Submission by Mallard Pass Action Group (MPAG)
– unique ID ref. 20036230

ALC and BMV assessment – reports and background

Report on Mallard Pass Solar Farm ALC.

Critique of ALC Report

Plan KCC3051/01A
Auger Point Plan

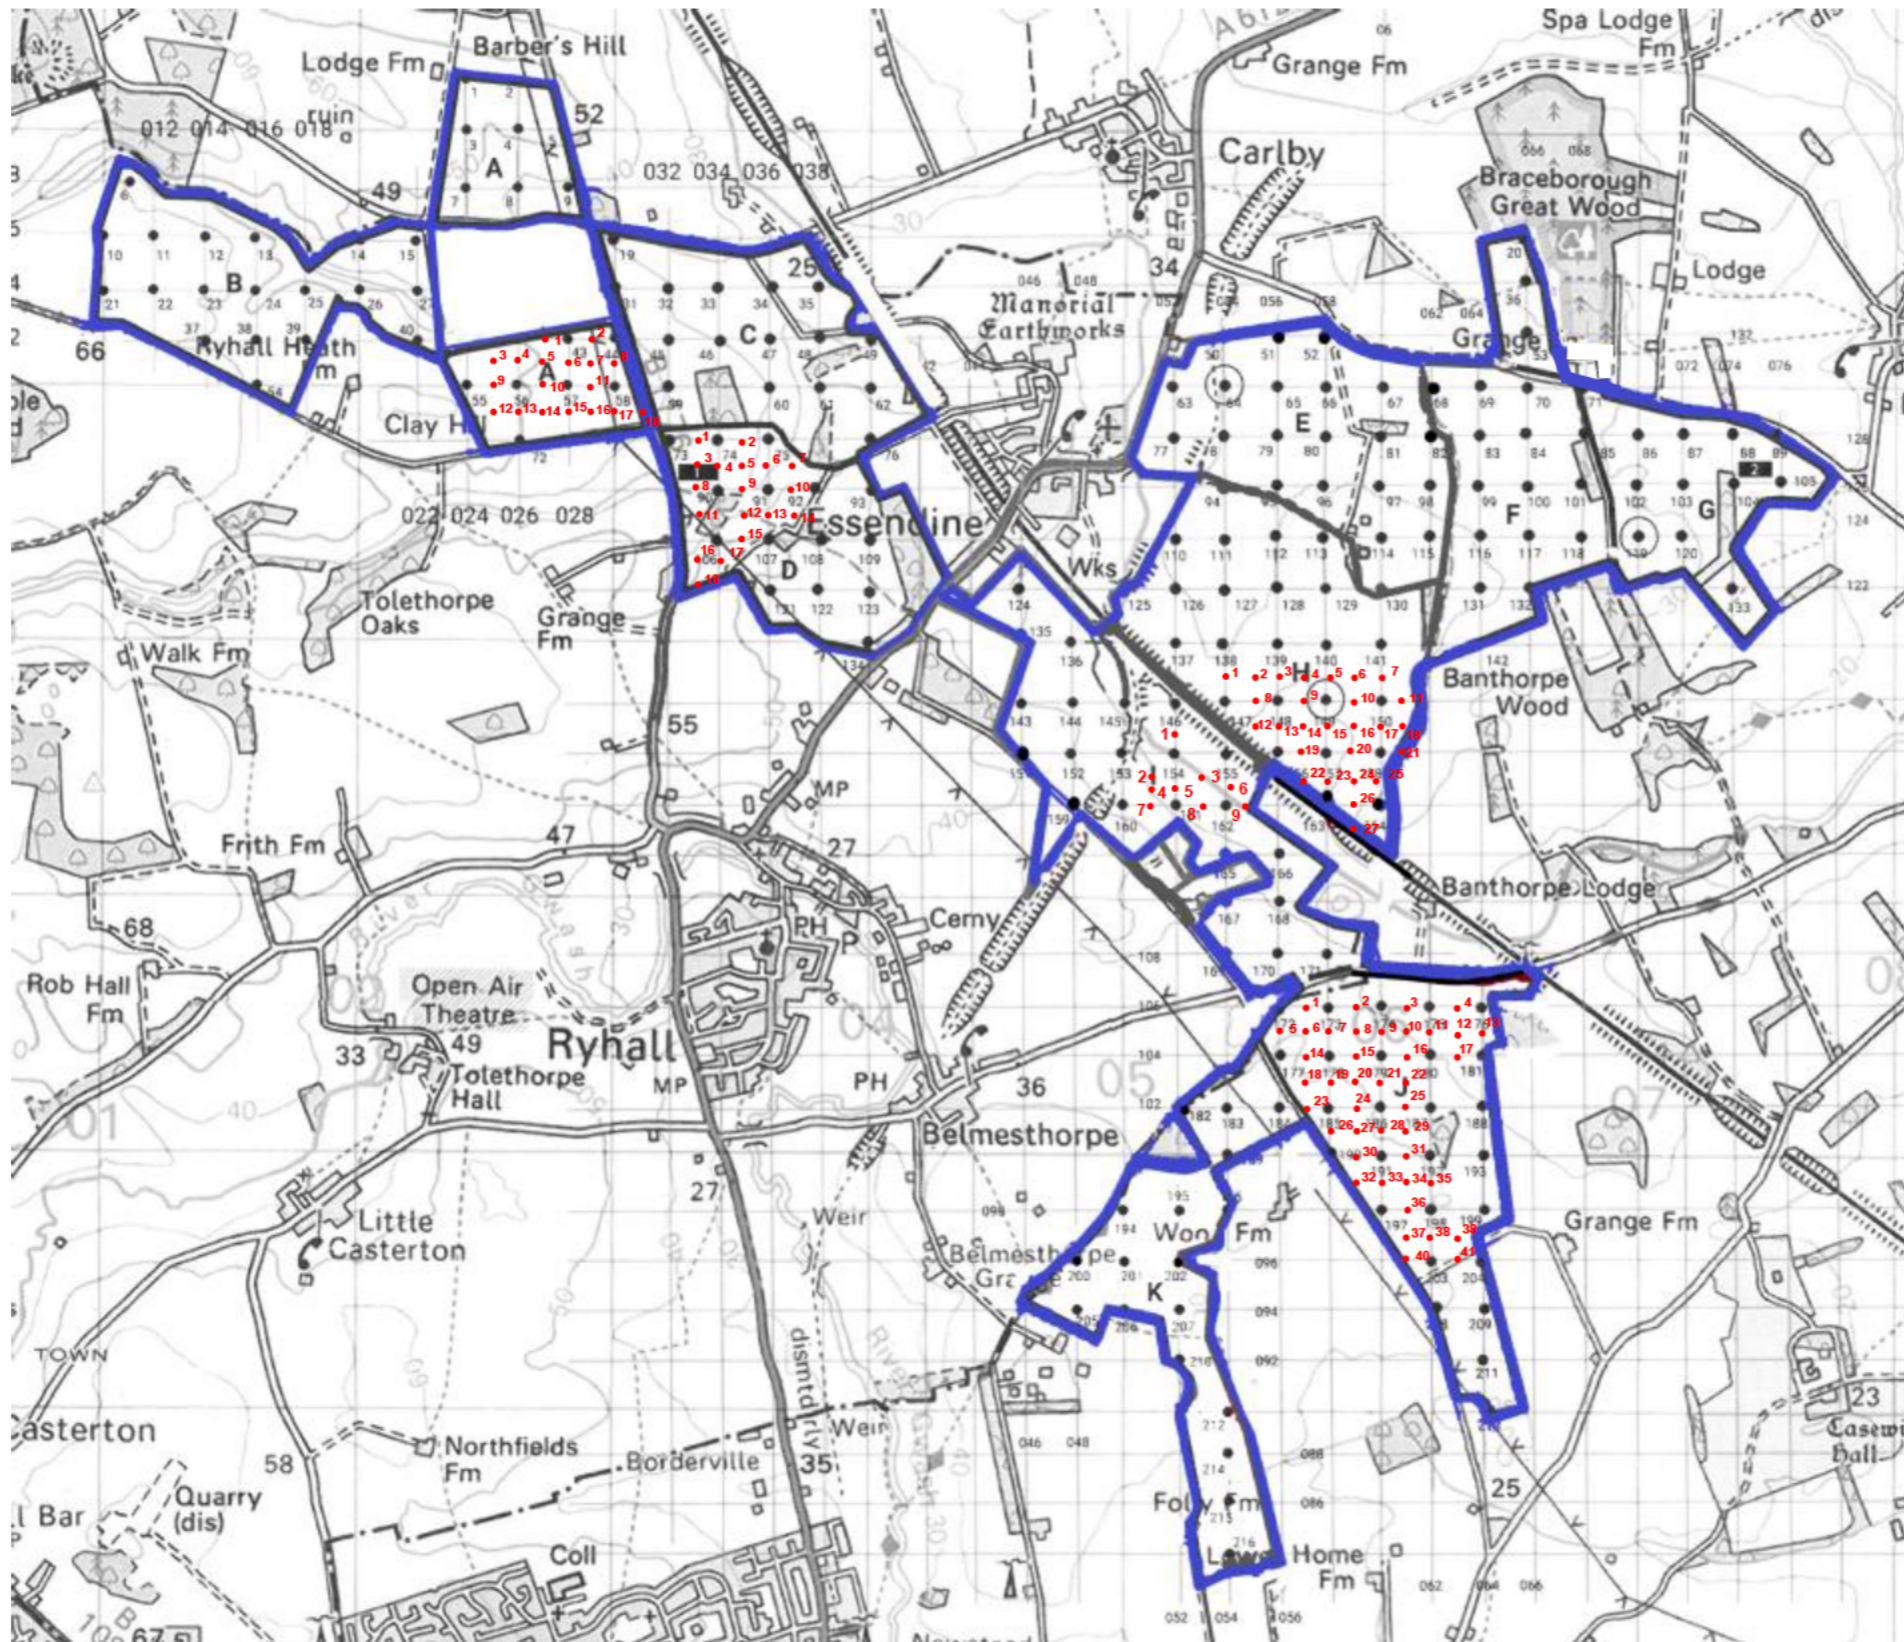
1.5 Even though Field 2 is 30 hectares, a total of only 24 samples in total were taken by the two KCC surveys, leaving a shortfall of 6 samples (a 20% shortfall). Despite there being four different grades of land and at least five different topsoils, no soil pits were dug in Field 2, even during the resurvey. It

5.4 Generally, soils were similar at points 2 and 6, but with deeper profiles at point 7 and 11. Broadly we concur with the findings of the KCC report that the area contains 3b, but we consider there is more 3a land than stated in the second report. There is clearly local variation with stoniness and relative shallowness of soils, variable across the site.

5.5 Point 9 was found to be much deeper and found to be Grade 2 land. A soil pit was dug at this location and significant stone was not found until 90cm depth. We consider that this widens the area of Grade 2 at this point rather than reduce it, as has happened in the KCC report.

5.6 Points 14 and 15 were found to be similar to the KCC findings, except that point 15 was a deeper profile, suggesting that the land is in fact Grade 3b rather than Grade 4. A further sample point was taken in this area for clarification. In general, the area of Grade 4 is about half that found by KCC. The attached **Plan 3** shows the ALC grade map.

Figure 12.1
ALC Across Order Limits

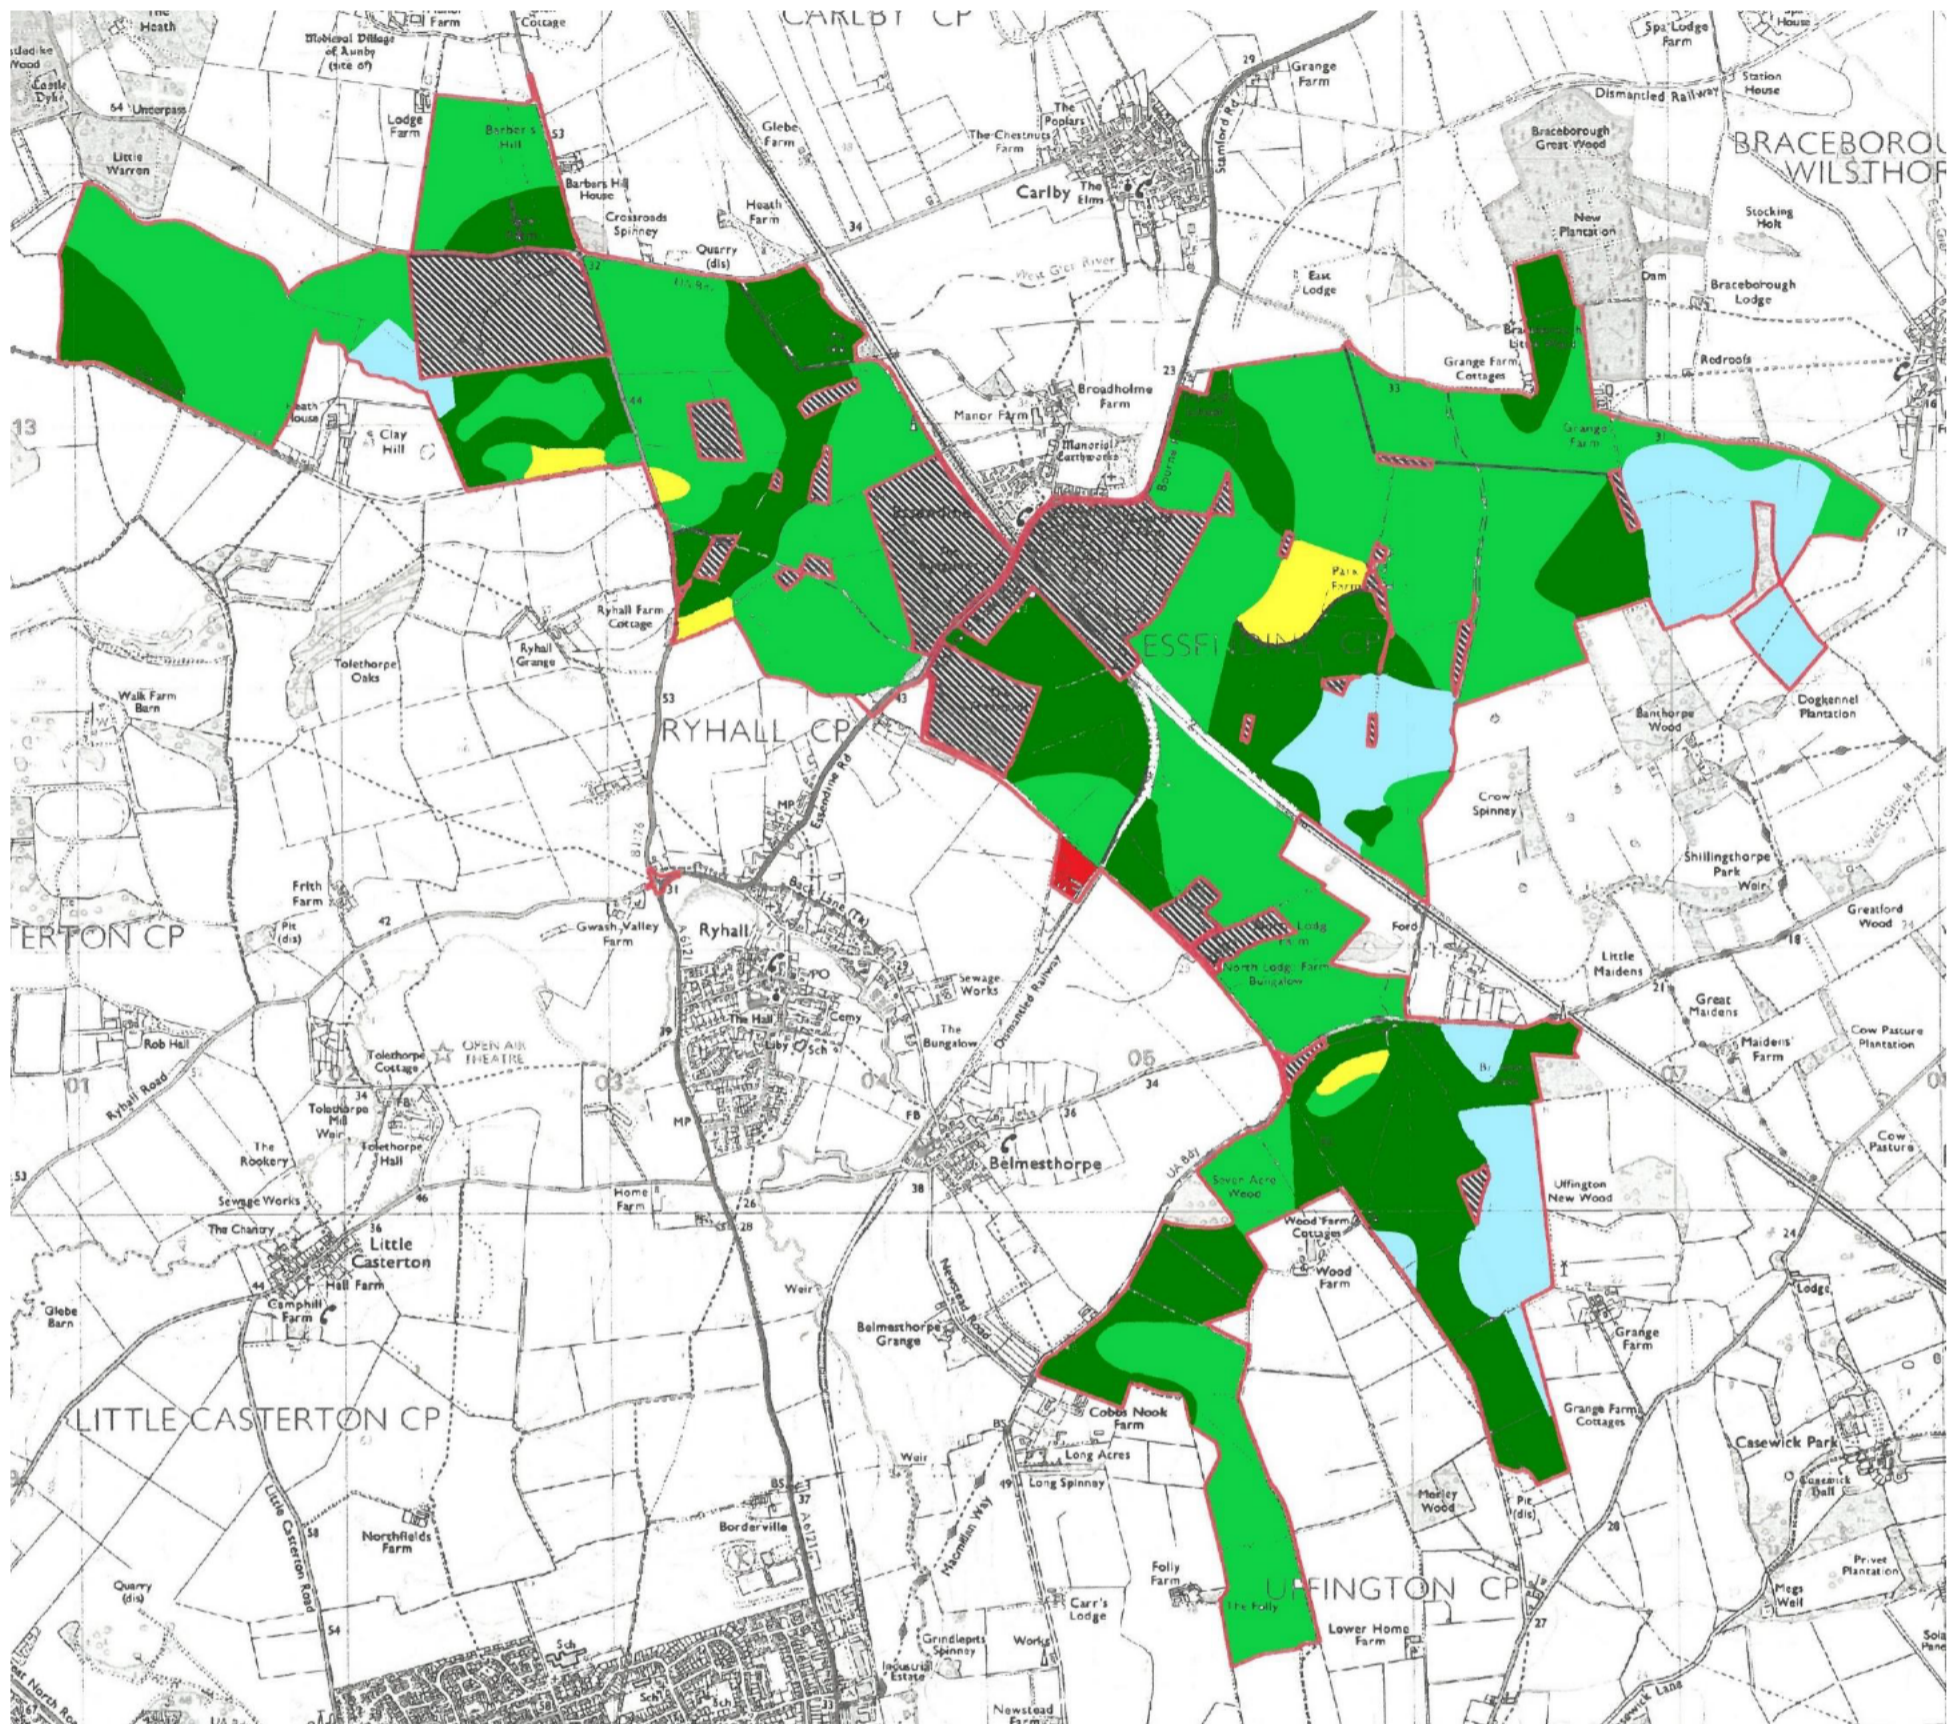
2.4 Fields 1, 2, 5, 11, 18, 19, 20, 21, 27, 28, 29, 36 & 45, (**Plan 2**) all have areas where there are changes to the grading plans, but those areas were not re-surveyed (see **Analysis Chart 1**). In each case, land is shown to be downgraded (mostly from 3a to 3b) without resurvey. In total and following the resurvey of parts of the site, the balance of BMV has now changed from 48% BMV to 42.2% BMV – a total reduction of 70 hectares. However, less than half of this change is due to the resurvey, the remainder is unexplained changes to the maps.

7.1 Based on the findings from our survey of a sample of the whole site, we consider that the Agricultural Land Classification findings of the KCC ALC report have not identified all the best and most versatile land on the site. Areas preliminarily identified as Grade 3b and not resurveyed may contain quantities of 3a or higher grade land.
